PLANNING (LISTED BUILDING AND CONSERVATION AREAS) ACT 1990

LISTED BUILDING

Reference: H13-0459-25 **Date of Decision:** 31st July 2025
Applicant: Moulton Windmill Project
C/O Swann Edwards Architecture Limited
Black Barn
Fen Road
Wisbech
PE13 4AA
Location: The Mill High Street Moulton Spalding
Description: Proposed siting of photovoltaic panels on existing roof

Front Elevation (SE)
Scale: 1:100

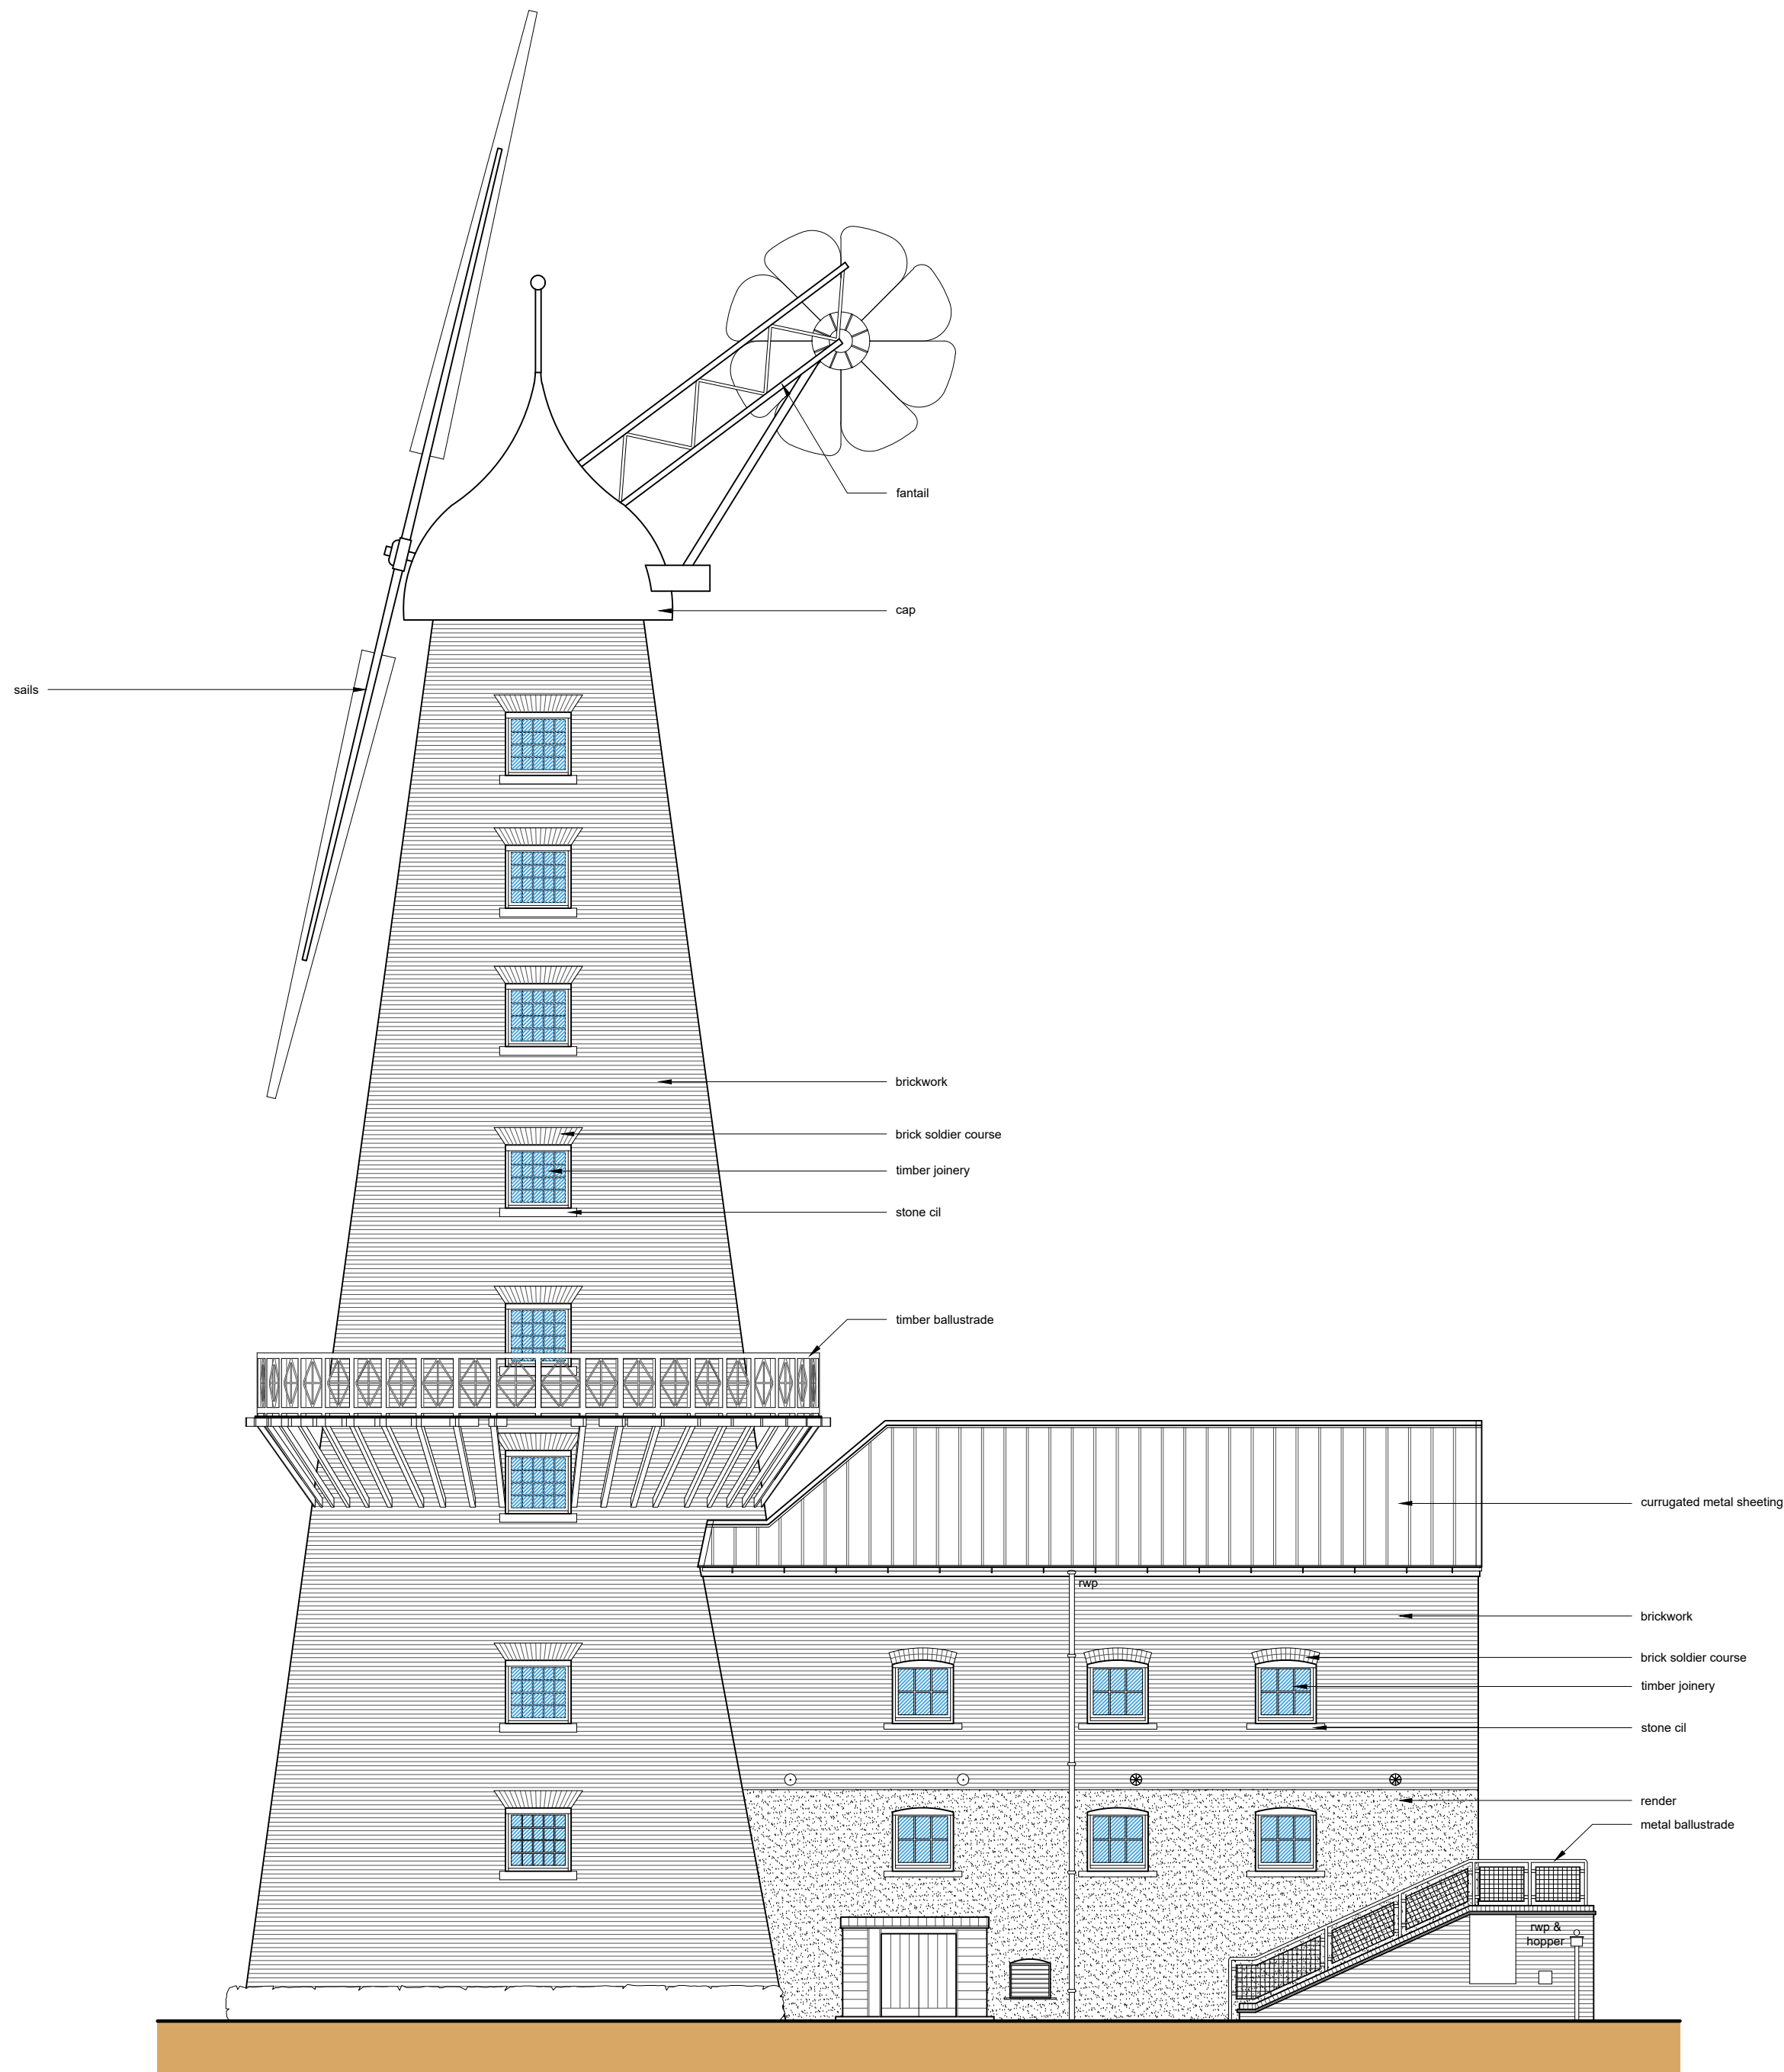
- 1 The proposed solar panels would create a stark and incongruous addition to the southern roof slope of the former granary building, which, when viewed in the context of historic character of the Grade I listed building such installation would adversely affect the architectural and historic character of Moulton Mill.

The proposal is therefore contrary to Policies 29 and 31 of the South East Lincolnshire Local Plan, 2019 as there would be harm to the heritage asset including its setting, nor is the Local Planning Authority satisfied that that the proposal does not involve alterations prejudicial to the special architectural interest and setting of the listed building.
